**SSD-45024776 – Narwee Parklands Seniors Housing at 59-67 Karne Street North, Narwee
Submission to the State Significant Development Application – Canterbury Bankstown City Council**

Attachment A
State Significant Development Application SSD-45024776 – Canterbury Bankstown
Council Submission
59-67 Karne Street North, Narwee

Figure 7 - PMF Level & Depth – Existing Conditions

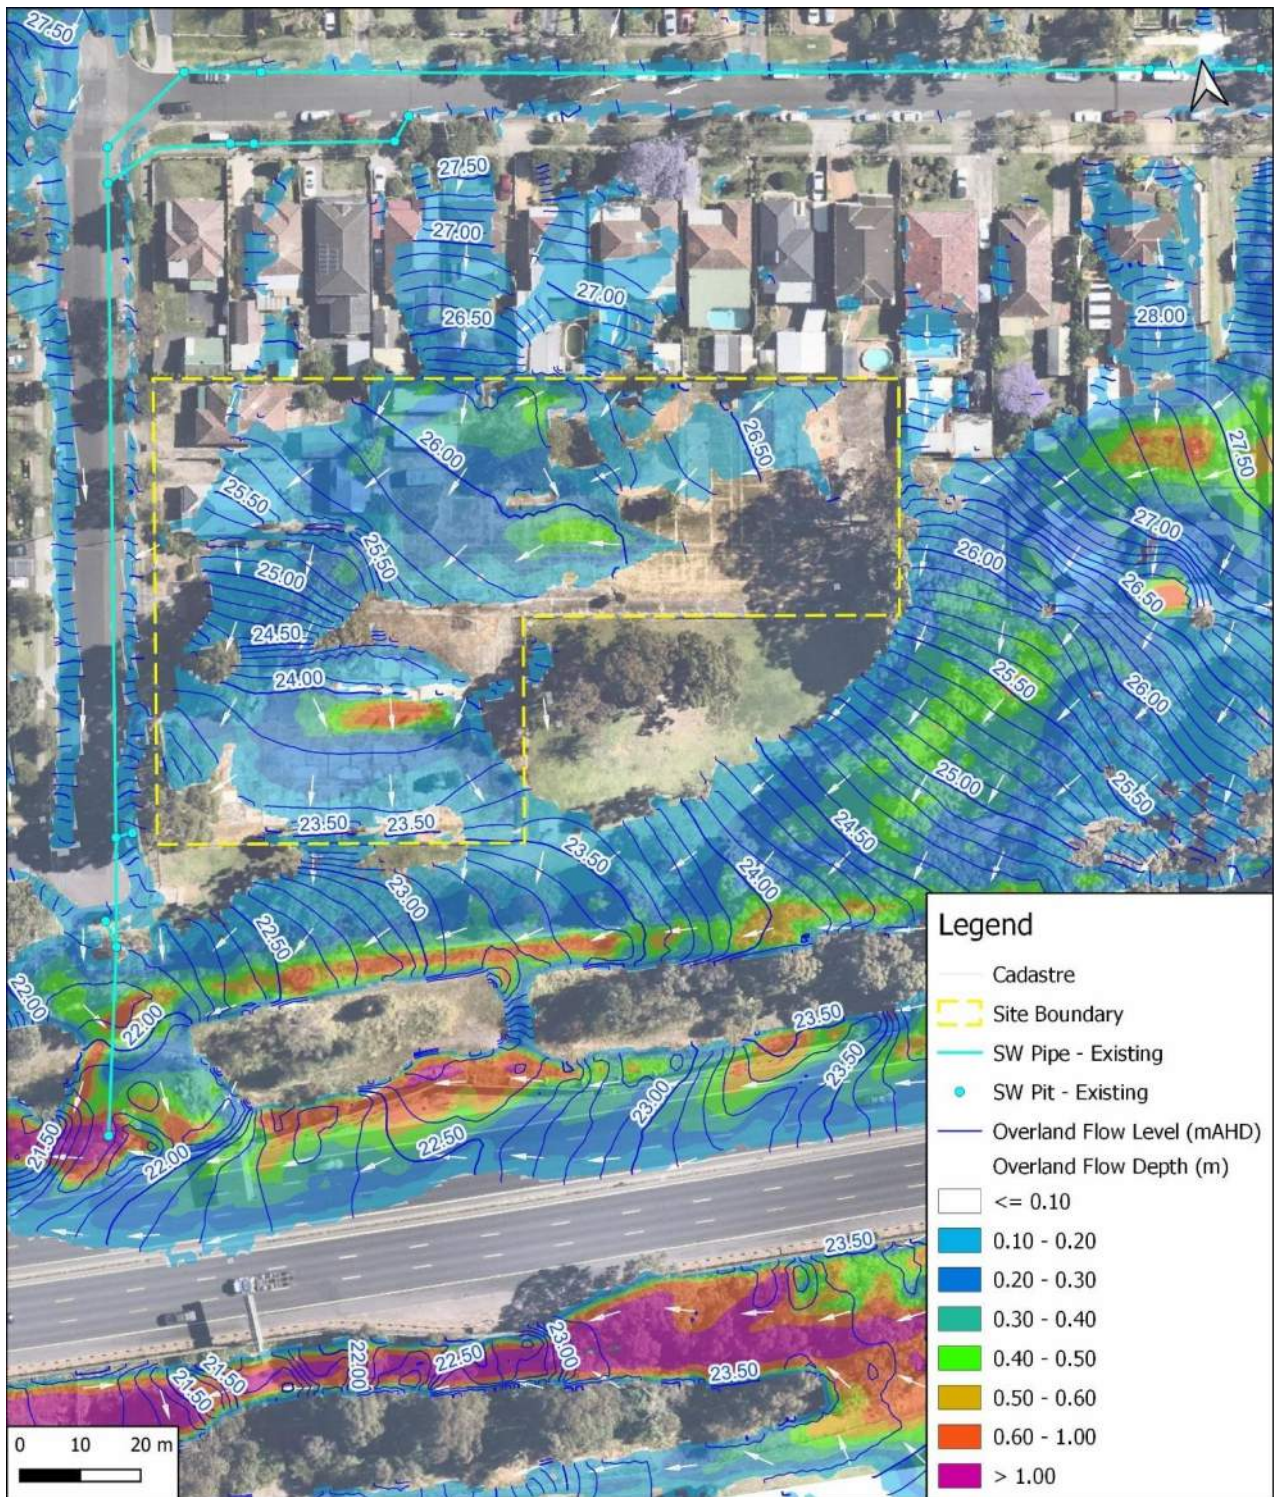
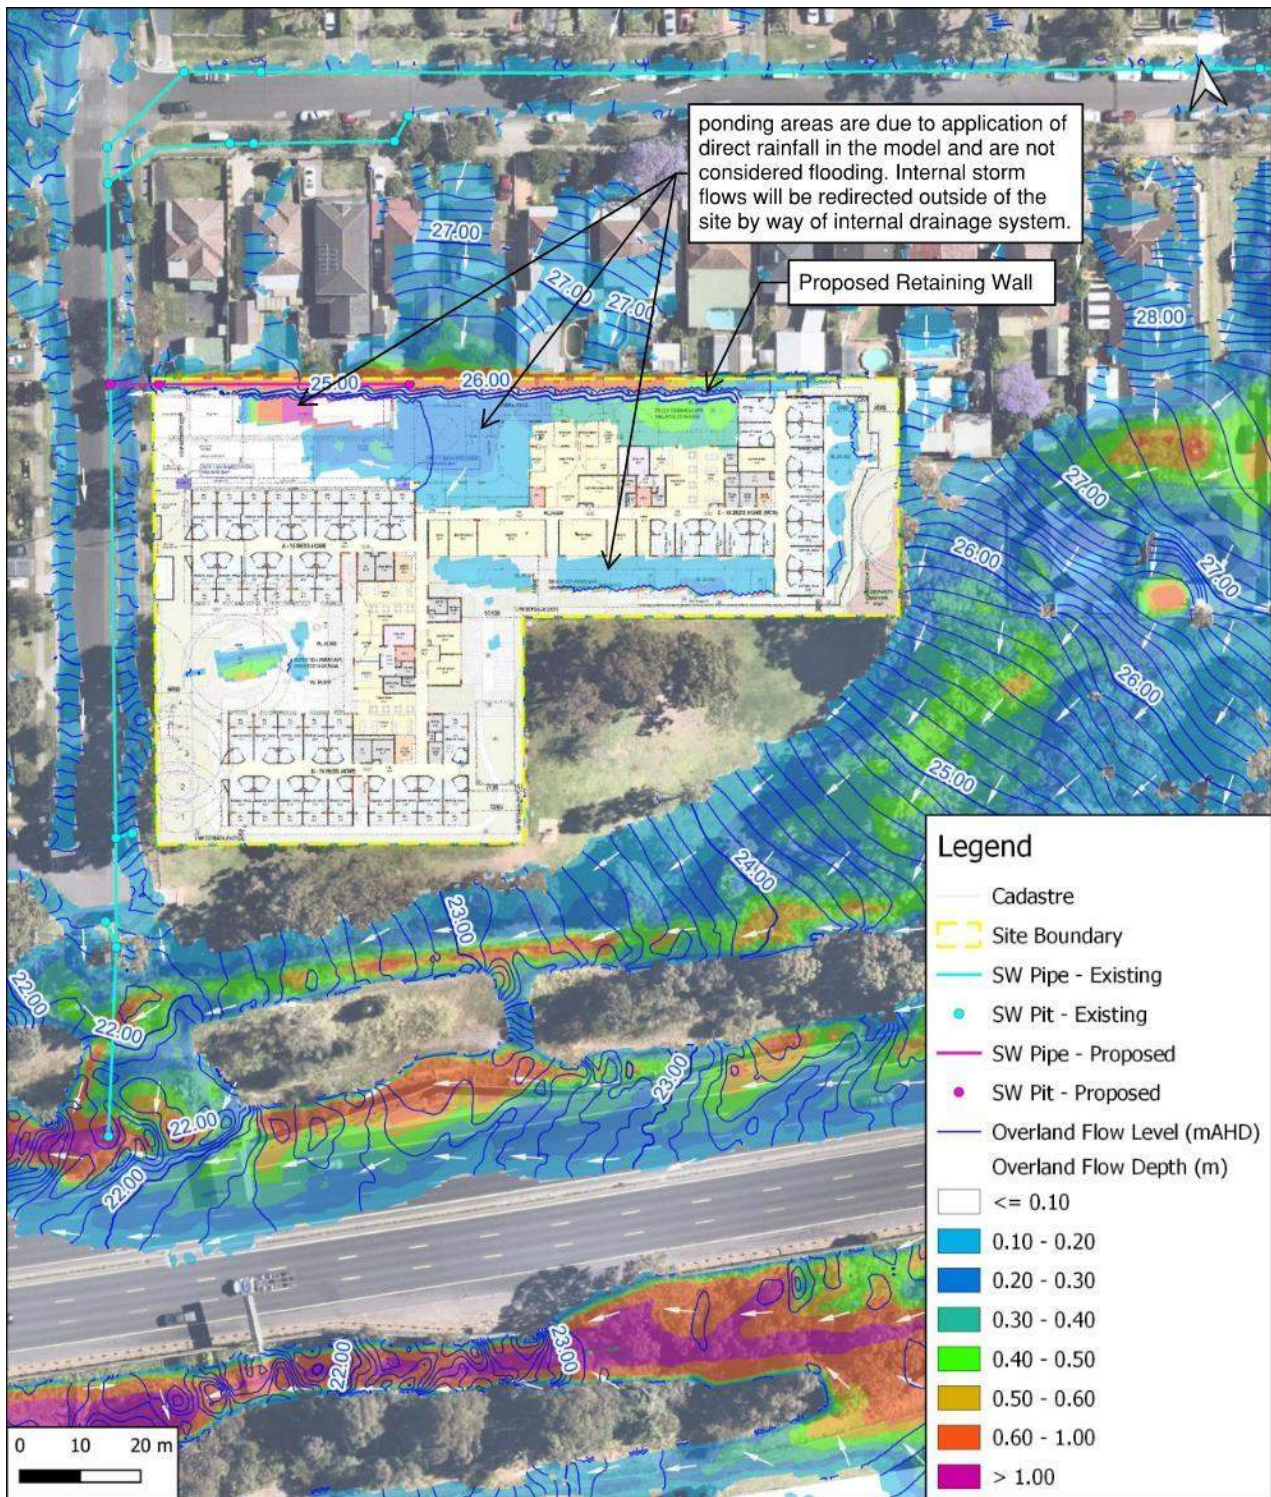
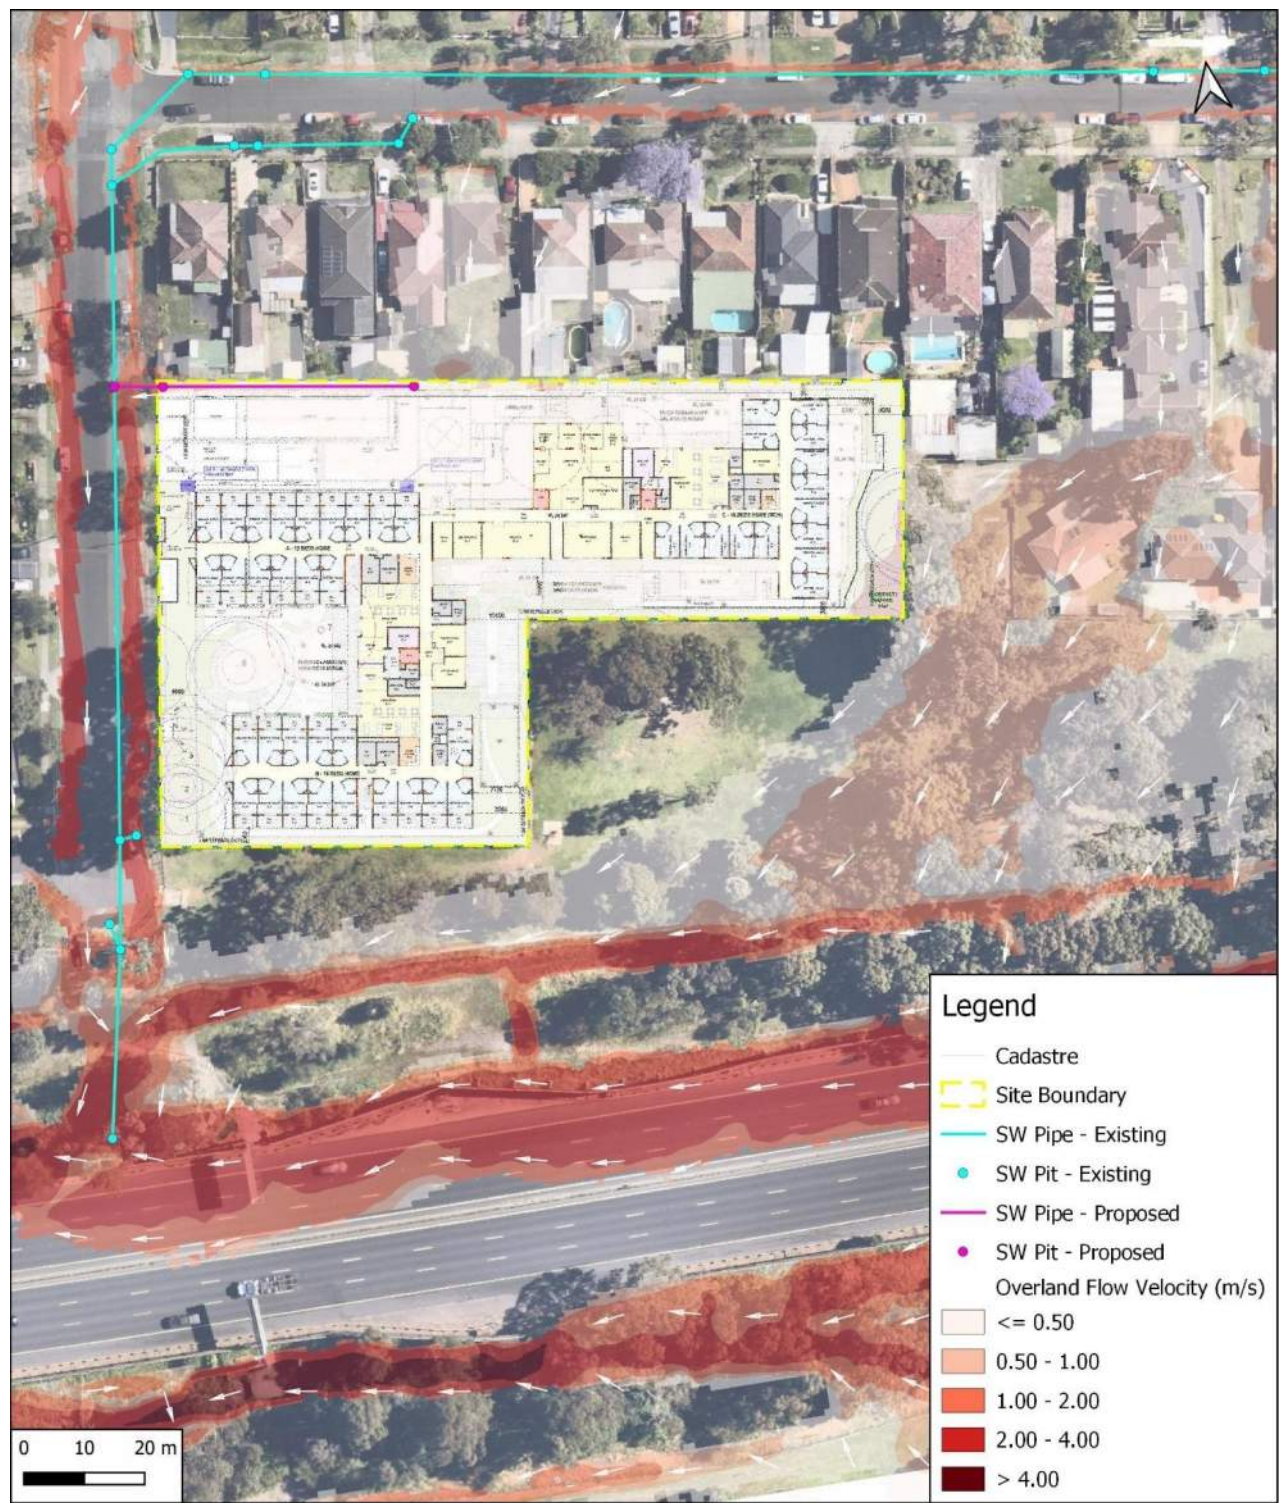
Flooding	<p>As per the flood assessment produced by TTW NSW, the existing peak flow entering from the northern site boundary is up to 190m³/sec in the 1% AEP event (page 10). Yet the PMF event is noted as 2.3m³/sec. A flow of 190m³/sec is considered to be an error as the volumes are too high for this site. The existing peak flood levels should be reviewed and revised with the correct volume figures.</p> <p>Given the above, the proposed development does not adequately demonstrate consistency with the Bankstown Development Control Plan 2015, DES and the NSW Floodplain Development Manual. Moreover, the development will need to demonstrate no worsening of flood conditions as a result of the proposal.</p> <p>It is requested that a development consent condition is included by the Department for a Flood Emergency Management Plan and evacuation routes endorsed by the State Emergency Service (SES) to be provided prior to any Construction Certificate being issued.</p>

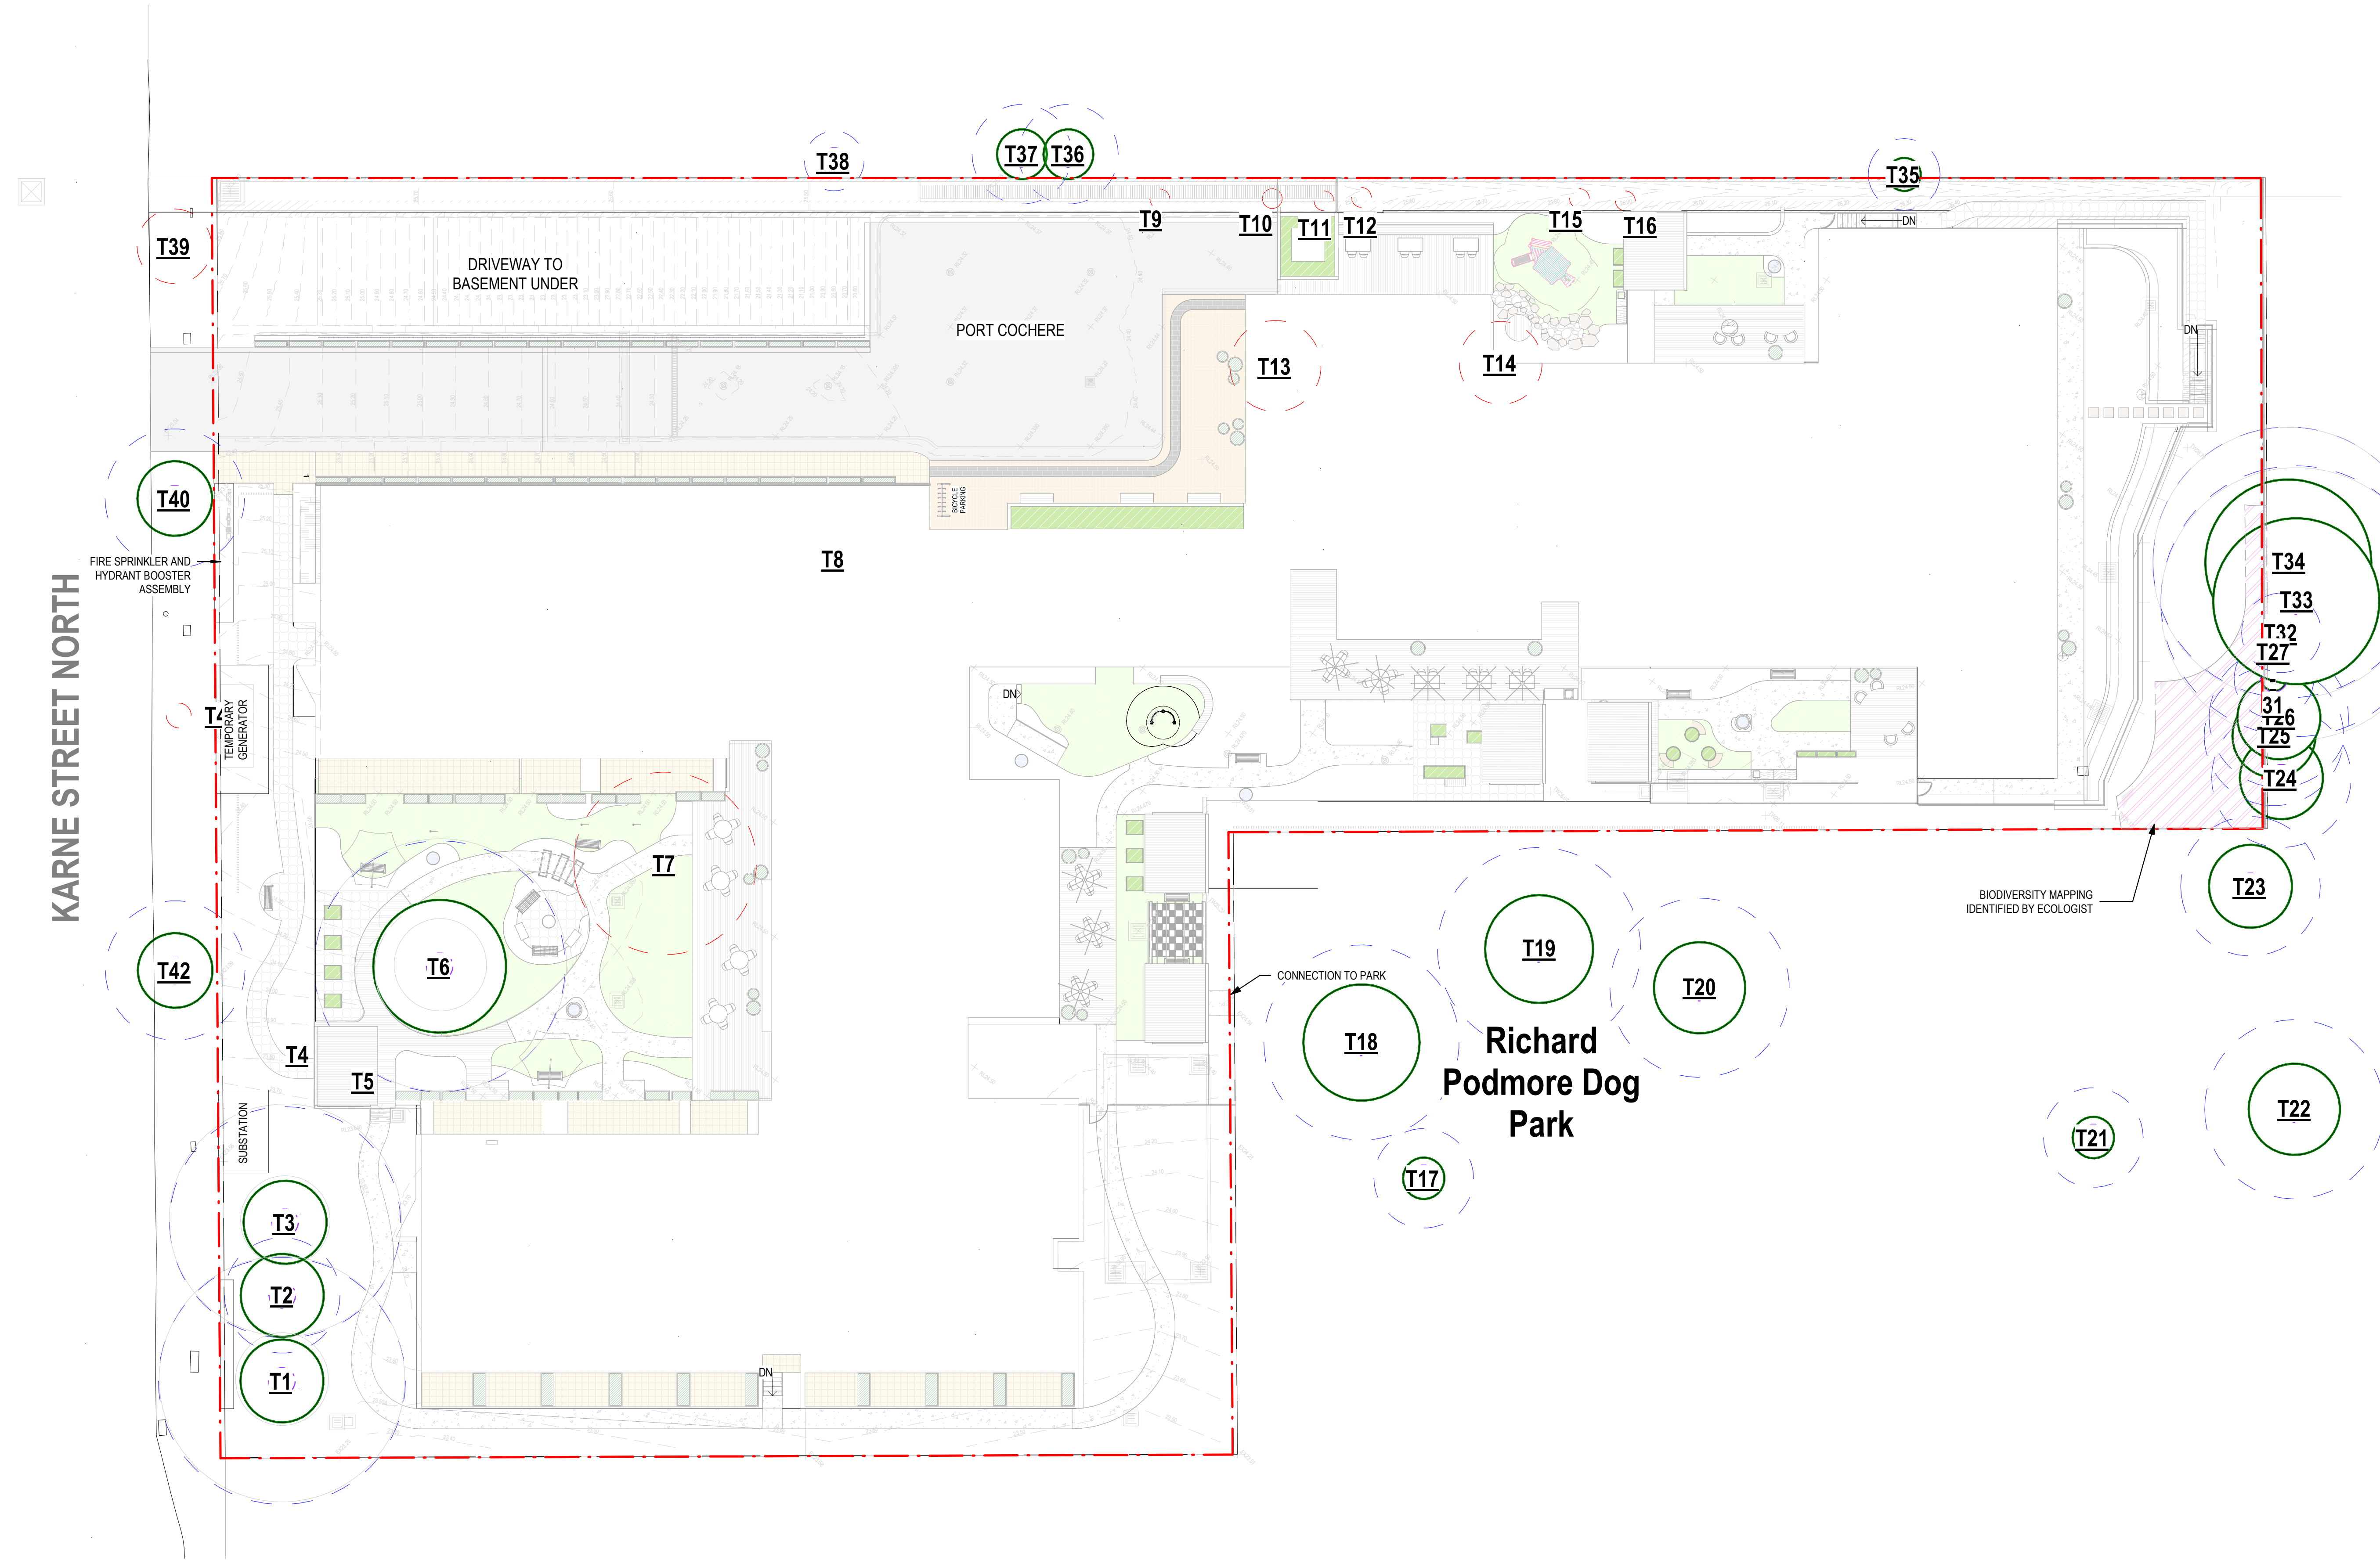
Item	Council Feedback
Landscaping	<p>The landscape plans/documentation should be updated to include the following information:</p> <ul style="list-style-type: none"> • Heights of all trees at maturity in accordance with the Secretary's Environmental Assessment Requirements (SEARs) • Further detail in relation to the proposal's contribution to increased urban tree canopy cover or mitigation of urban heat island effect in accordance with the SEARs • The landscaping along the southern and eastern boundaries should utilise species consistent with the Plant Community Type (PCT) classification 3448 (Castlereagh Ironbark Forest). The landscaping in this area should also be managed under a Vegetation Management Plan prepared by a suitably qualified person (please see Figure 1 below).

The recommendations of the Arboricultural report prepared by Moore Tree Arboricultural Services should be included as conditions in a development consent and must be detailed on Construction Certificate plans. Council has reviewed this document in conjunction with the Architectural and Landscape Plans and note the following inconsistencies:

- Tree 39 is identified on the architectural plans to be located on the street verge to the side of the adjoining property at 84 Grove Avenue, yet the Landscape Plans note it will be in front of the proposed development and removed. The plans should be amended for consistency. Based on a site visit, this tree is located as per the Architectural plans.
- Tree 40 located on Council land is identified in the Arboricultural report and Landscape plans for retention, yet the Architectural plans note it will be

Item	Council Feedback
	<p>removed. This tree should be retained as it provides a positive contribution to the Karne Street North streetscape. Council does not support its removal. As per the provided Arboricultural report (page 2), no excavation should occur within 1m of the tree. The Architectural plans conflict this advice as the tree is within 1m of the proposed driveway. Further clarification is requested to ensure this tree is retained.</p> <ul style="list-style-type: none"> • Tree 41 located on Council land is noted as removed as it had died. This tree must be replaced with a new street tree which needs to be included on the plans. • There is ample opportunity for additional street trees along the site frontage to be planted. Council requests that the revised Landscape plan is submitted showing additional street trees to enhance the streetscape and contribute to increased tree canopy. • It is not clear on the plans if the protection measures recommended under the Arboricultural report can be implemented with the amount of excavation proposed. Please refer to the Excavation issue in this table for more information.
